1 July 2019

RMS Reference: SYD12/00236/17 and SYD17/00918/08
DPE Ref: SSD 5175 MOD 4 and SSD 8588 MOD 2

**MODIFICATION TO THE EASTERN CREEK BUSINESS HUB
ROOTY HILL ROAD SOUTH, ROOTY HILL**

drawing title
STAGE 1 PROPOSED PLAN

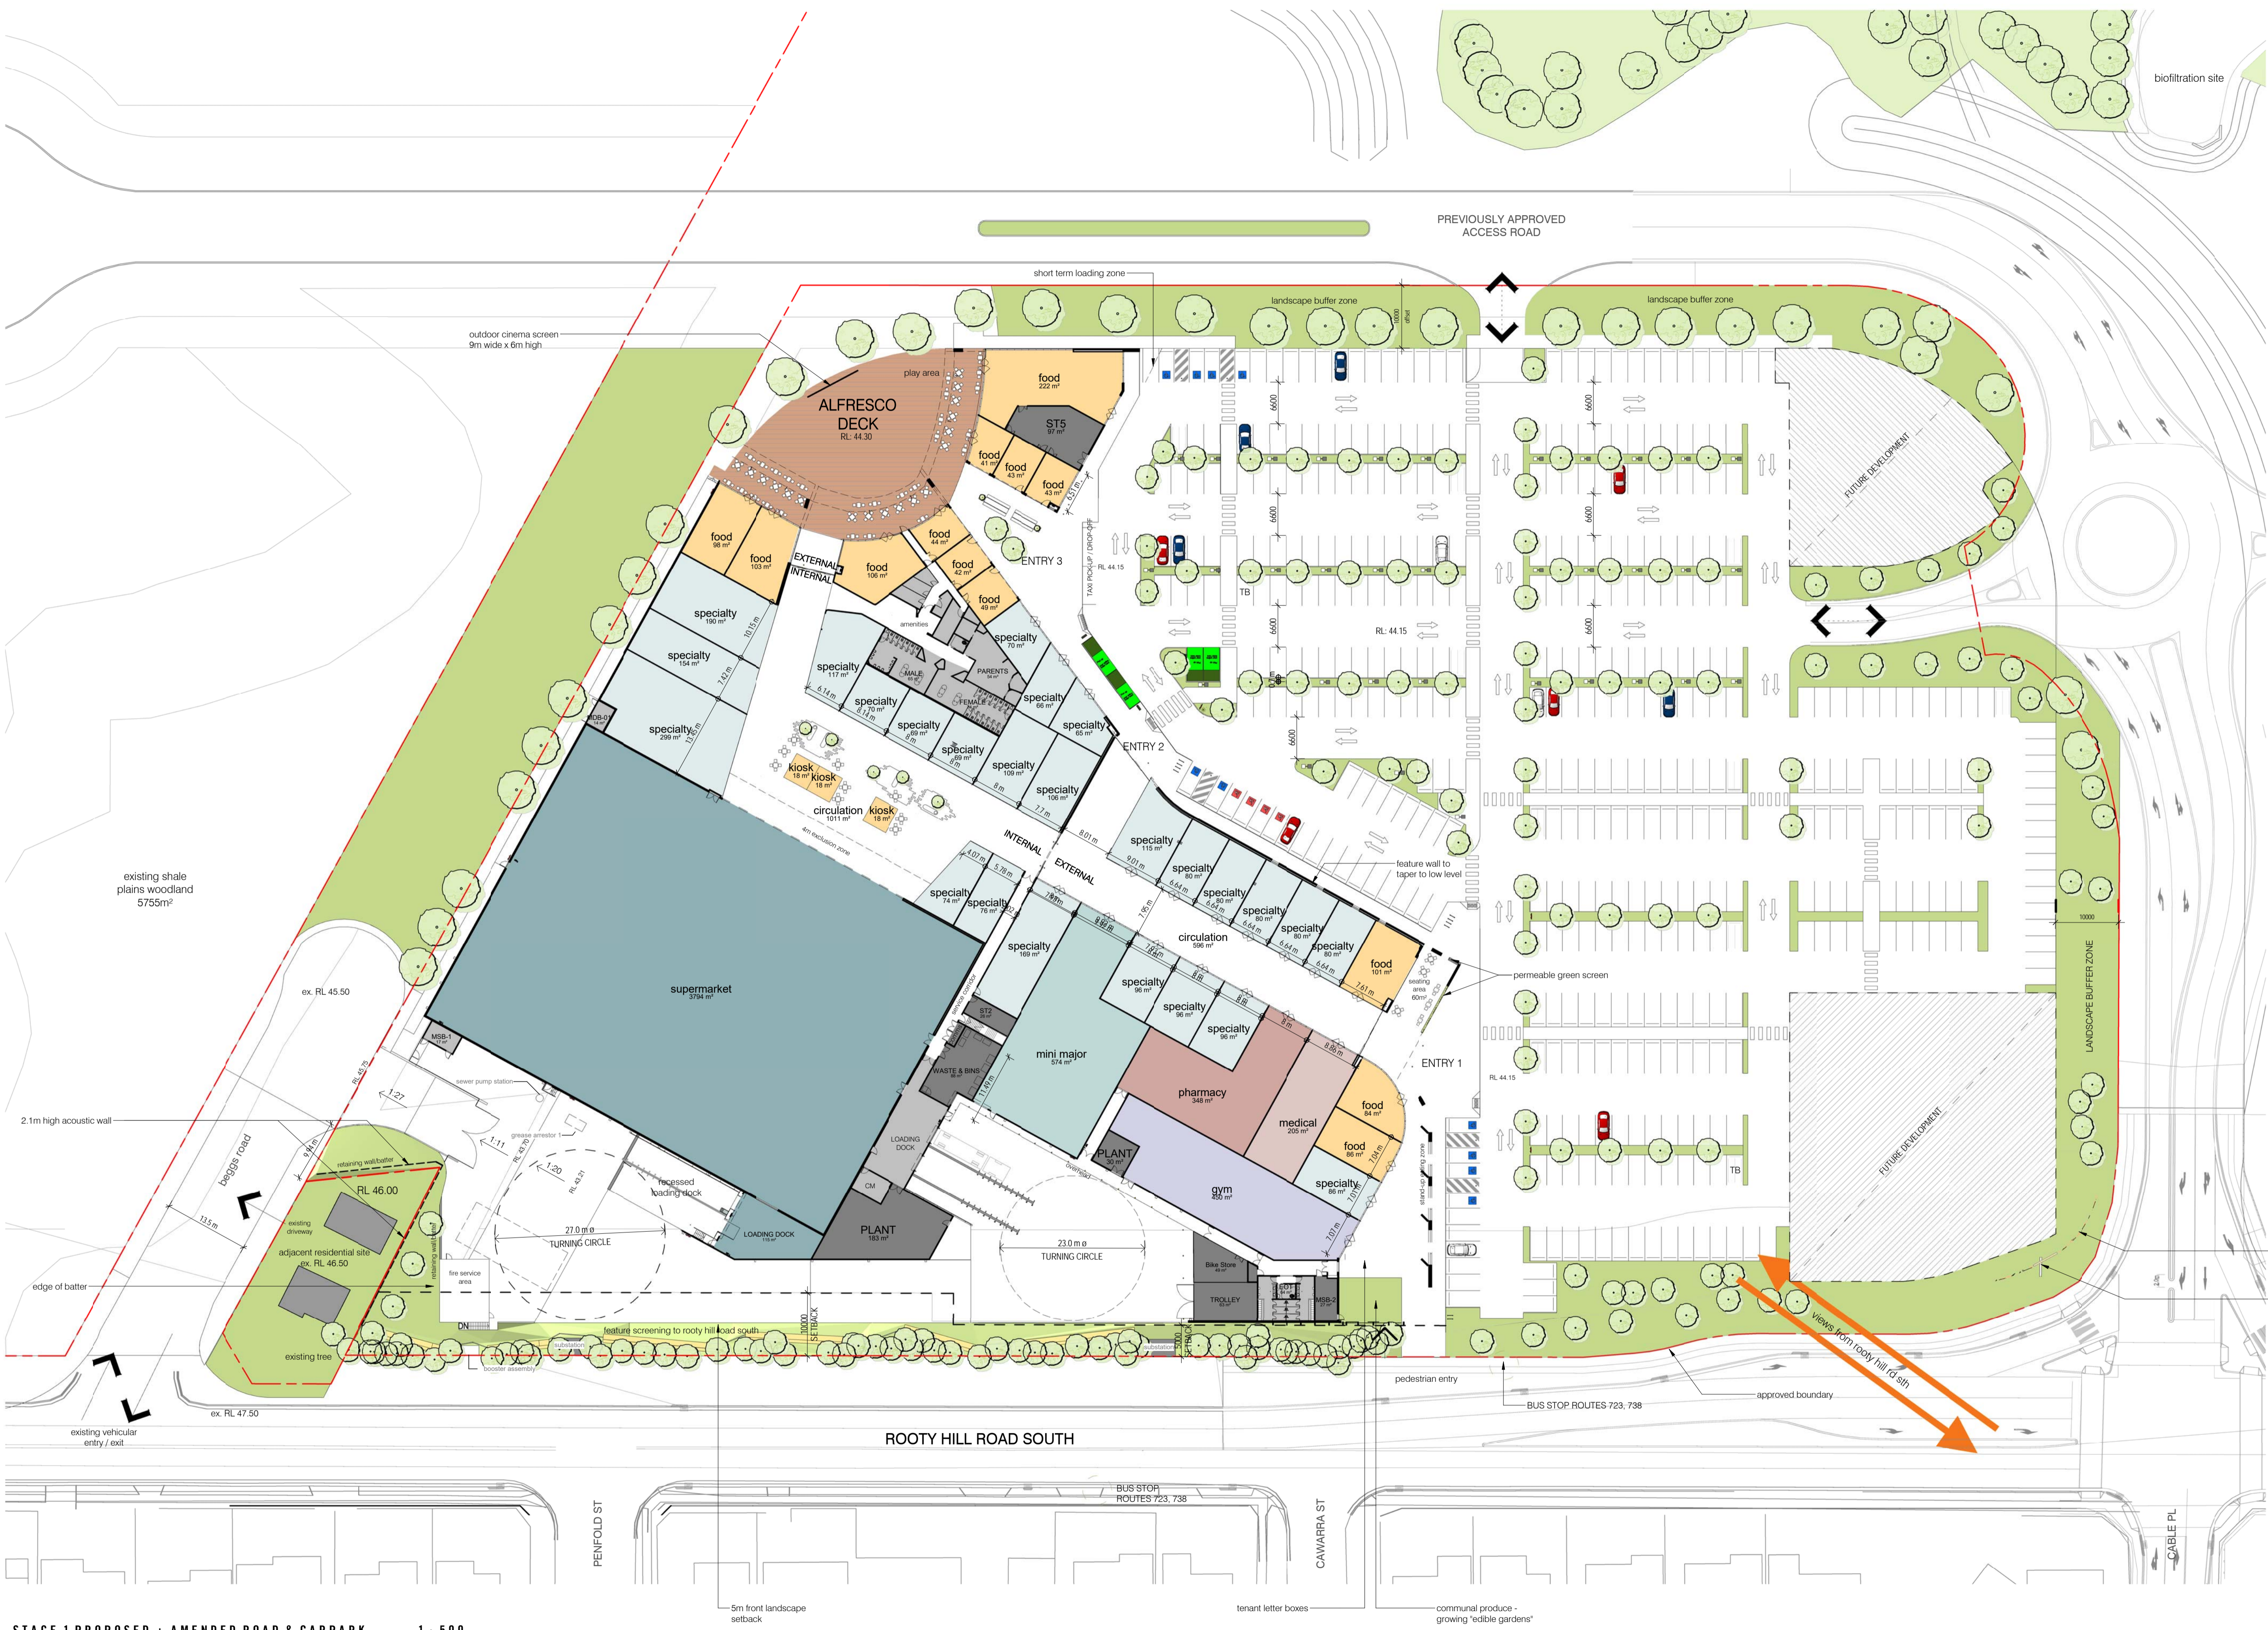
Roads and Maritime note that the design of the roundabout, in its current form may impact the functioning of the Rooty Hill Road South / Cable Place intersection. However, Roads and Maritime would have no objections, in relation to the construction of a roundabout, providing that the access to Lot 2 from the proposed roundabout is modified from an entry/exit access to an entry only access arrangement. Amended plans reflecting the above modification are to be submitted to DPE for their review and approval.
